DRB Application No.: 04DRB-00226 (SBP) AND 04DRB-00227 (P&F)

Project Name: RICHFIELD PARK

**CITY OF ALBUQUERQUE
PLANNING DEPARTMENT
Development Review Board
3/3/04 Comments**

RE: Lots 36 & 37, Richfield Park/SPBP & MINOR PLAT

A PROPOSED SITE PLAN
SCALE: 1" = 20'-0"

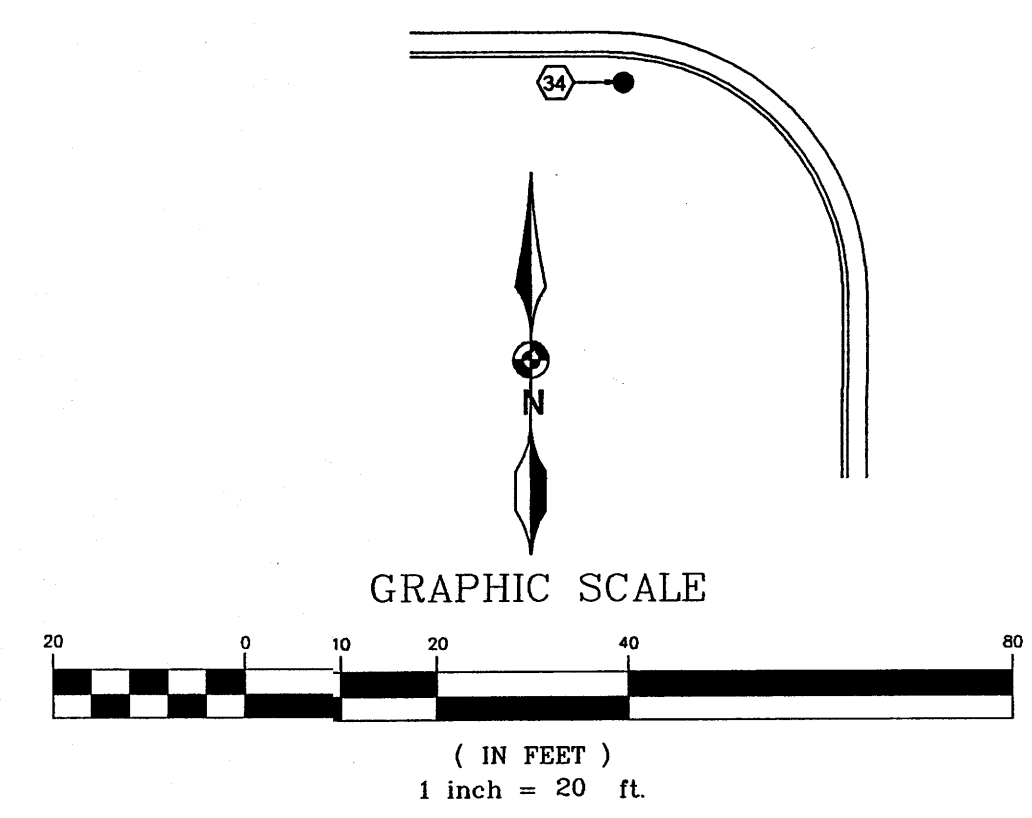
- The site plan should be titled "Site Plan for Building Permit" and the updated signature block should appear on this sheet.
- The square footage of each building as well as the proposed use should appear on the footprint of the building, not just in the notes.

- Keyed Note 5 refers to a CMU wall but points to the edge between 2 parking stalls. Where is the 4' CMU wall planned to be built?
- How high is the CMU wall along the south side of the property? Is it existing?

- Actually all the Landscape Notes should appear on the Landscape Plan.
- All buildings must have a 15 foot rear yard setback. These two buildings appear to have only a 5' rear yard setback from the property line.

5. Lighting: EPC Condition # 13 states that parking lot light fixtures are to be a maximum of 16 feet in height. The site plan lighting is 20' tall.

X MONUMENT SIGN (ELEVATION)
SCALE: 1/2" = 1'-0"

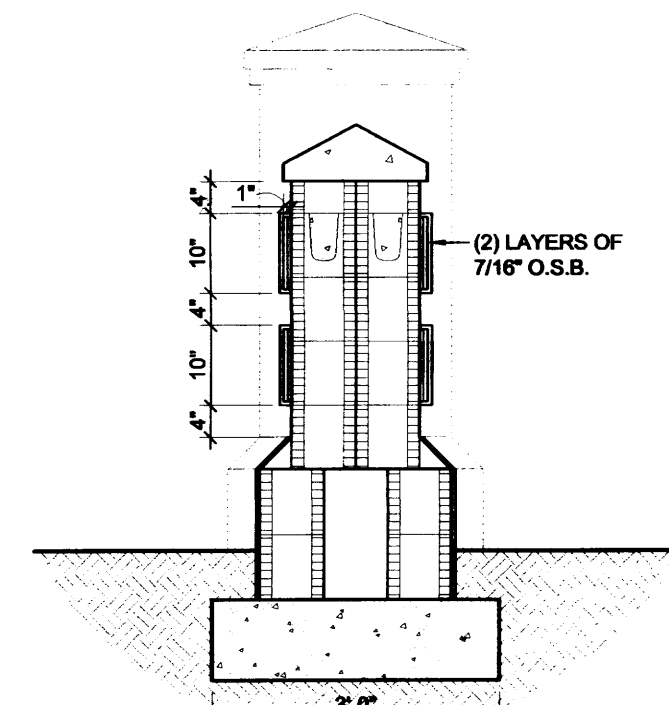
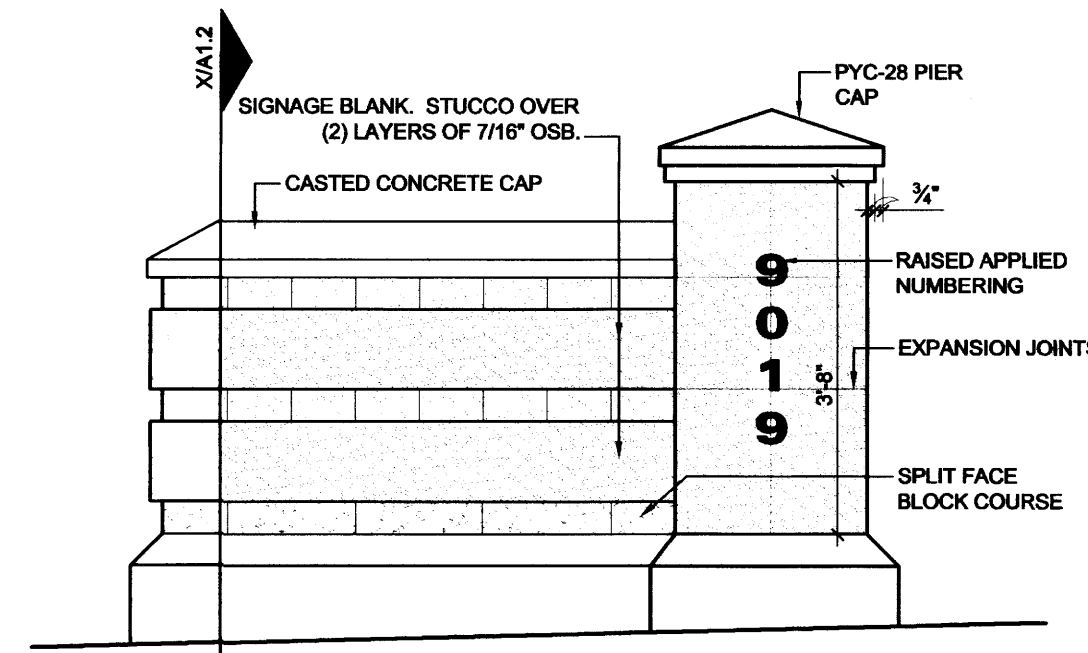
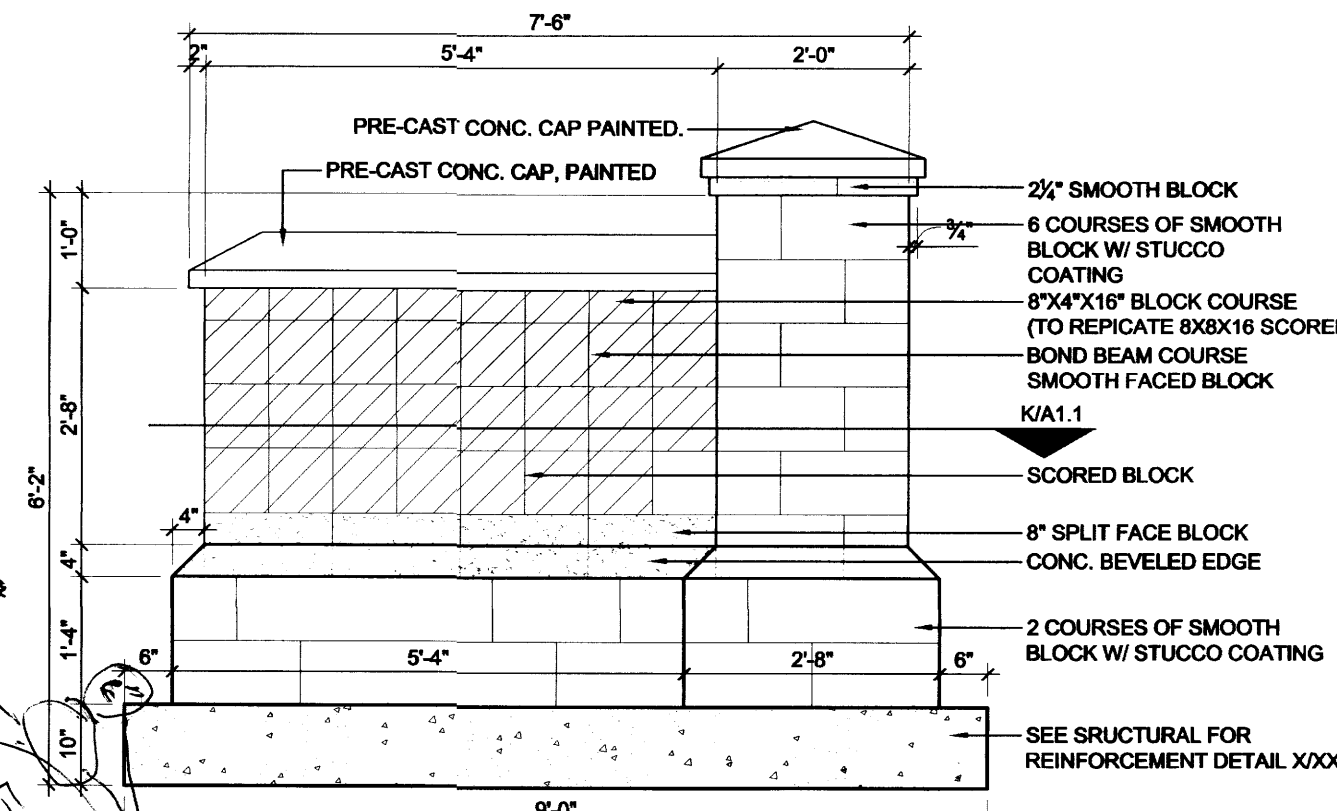
4. Monument Sign: The EPC conditions say this sign should not exceed 24 square feet. Even subtracting the underground portion of the sign (16"), the sign appears to exceed this maximum size by over 10 square feet. The height appears to be in compliance with the 6' maximum. Is the sign to be lighted?

LANDSCAPE NOTES:
Landscape maintenance shall be the responsibility of the Property Owner.

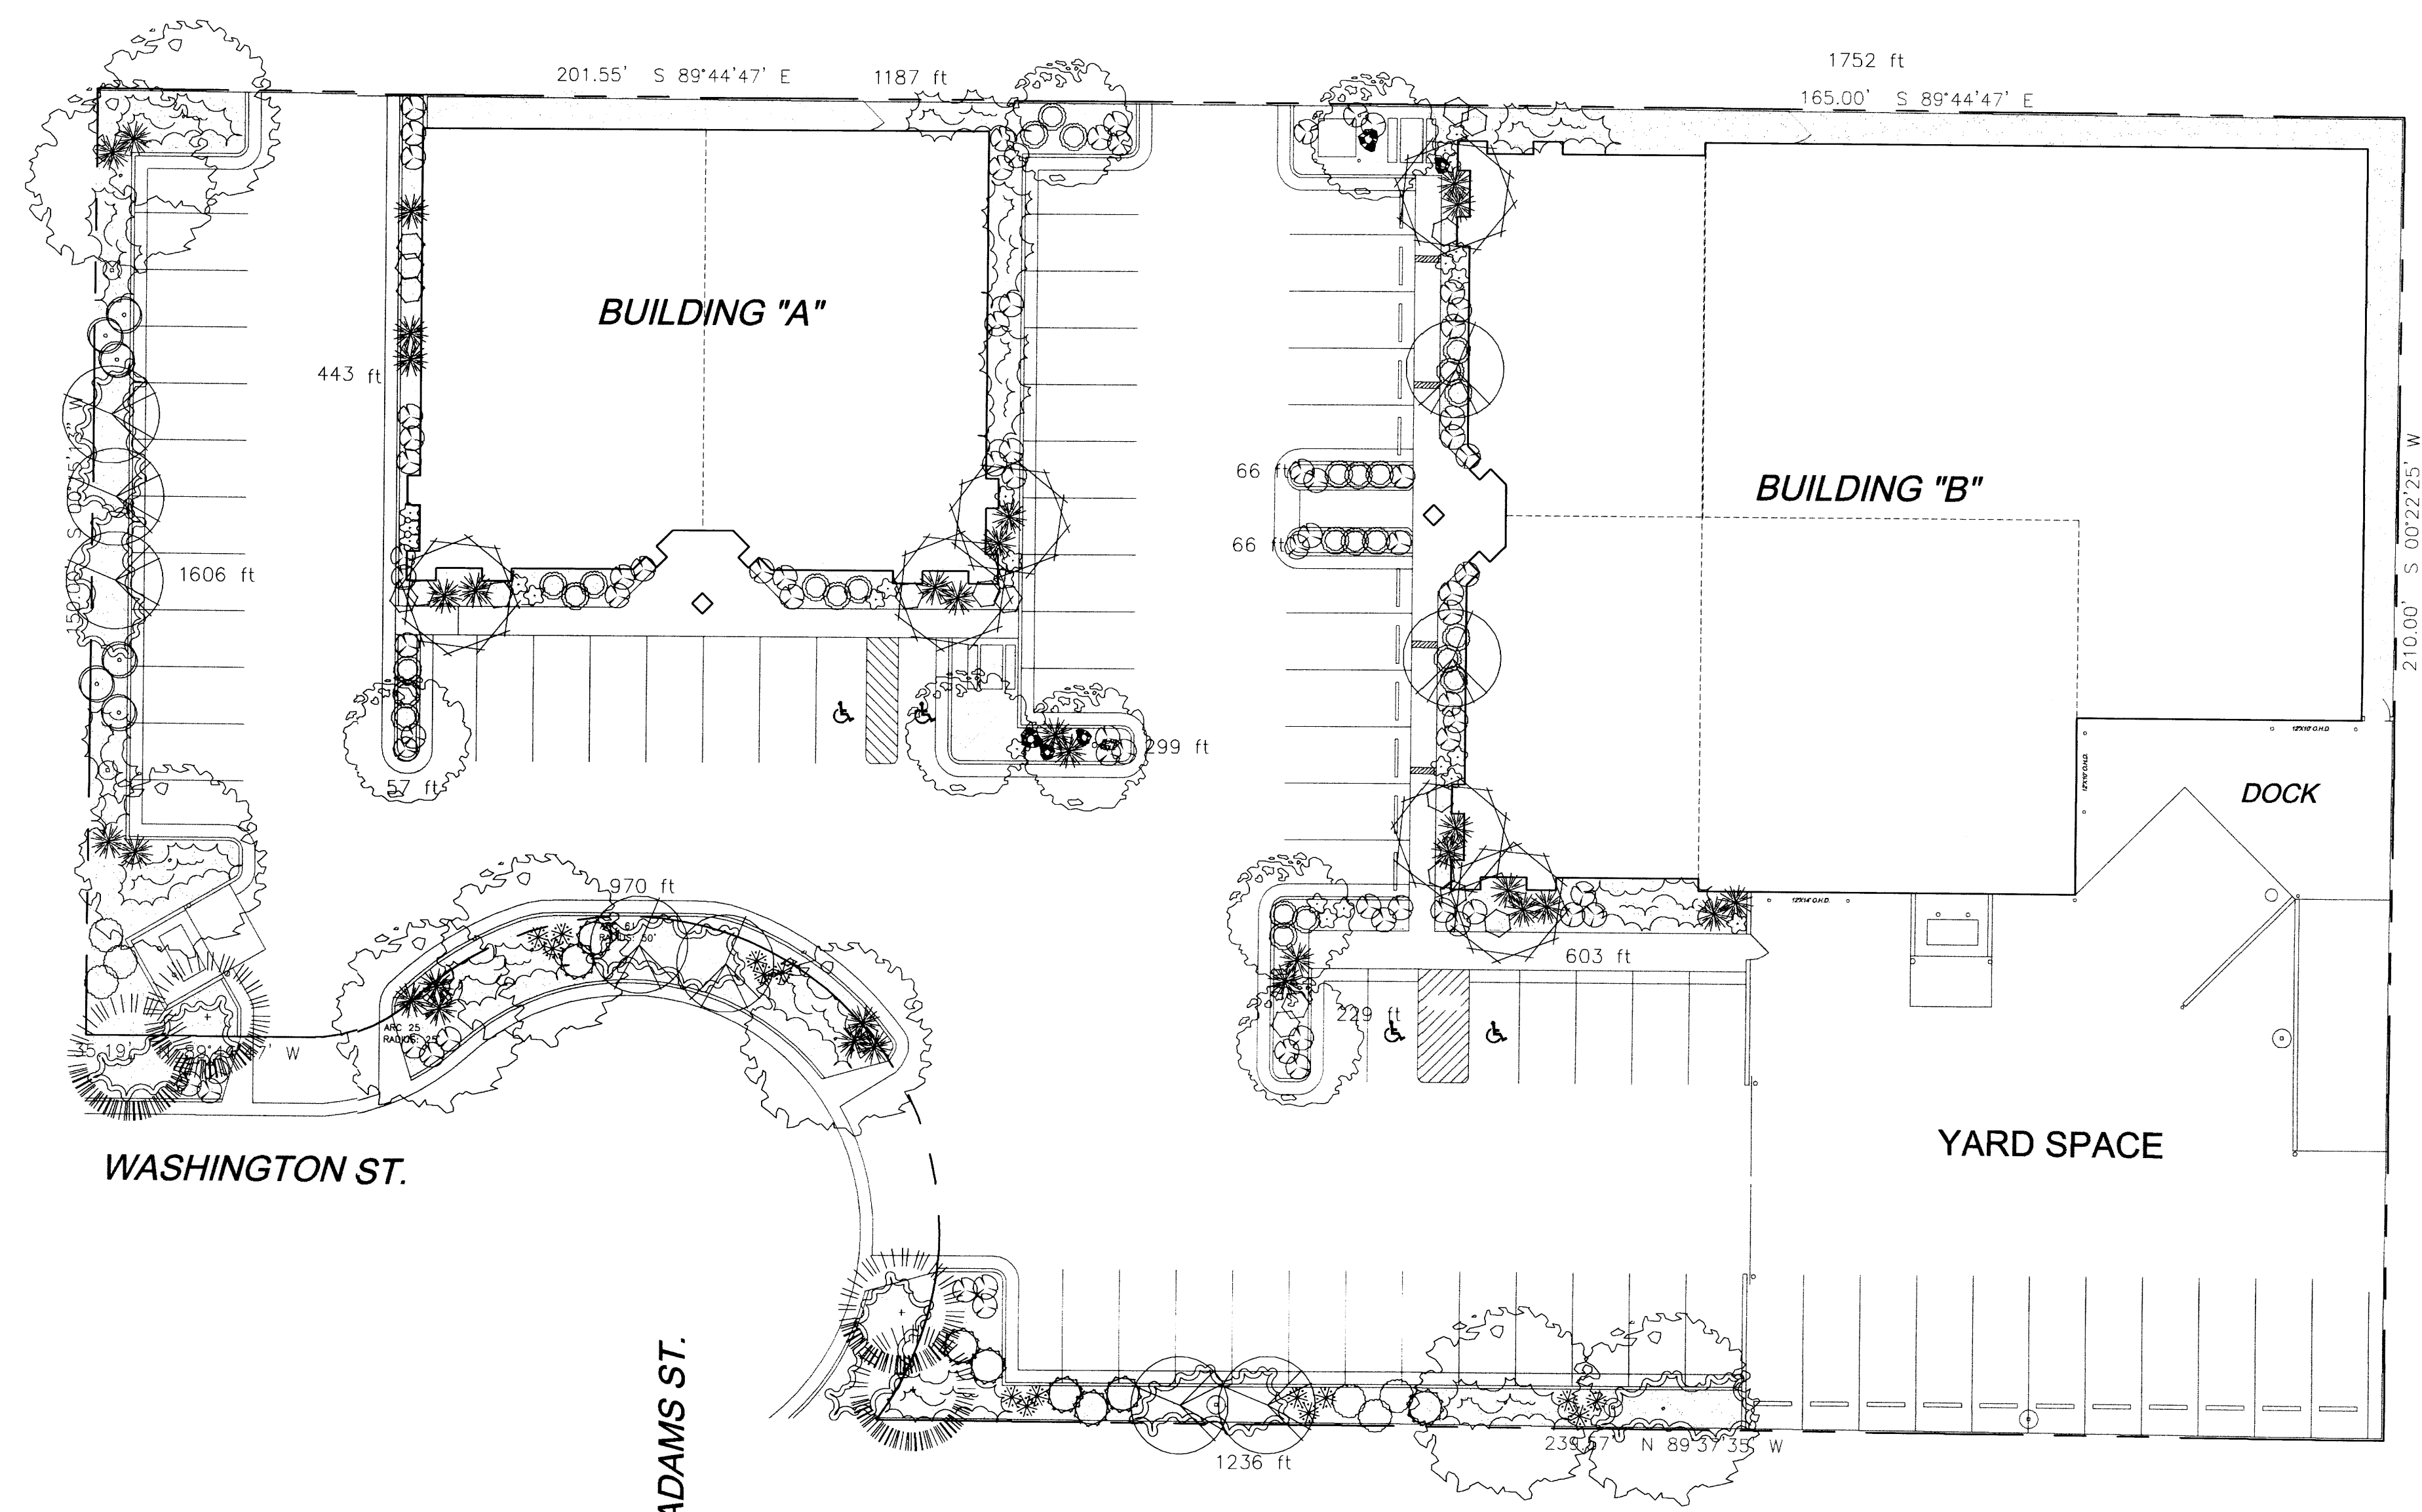
- Landscape Notes: #4 says that responsibility for landscaping & irrigation maintenance, including abutting public right of way, lies with the property owner of Lot 30A. On the Landscape Plan, the note says this responsibility lies with the property owner. Please correct this discrepancy.

- Please substitute other drought tolerant plants for the junipers. Junipers are high allergen plants. Rosemary is one possible substitute.
- Chinese Pistache needs a water use symbol.
- Each landscape bed should have the square footage listed by the bed. There is a footage noted for each bed. However, if this is the square footage, a change in the notes is needed to indicate as such.
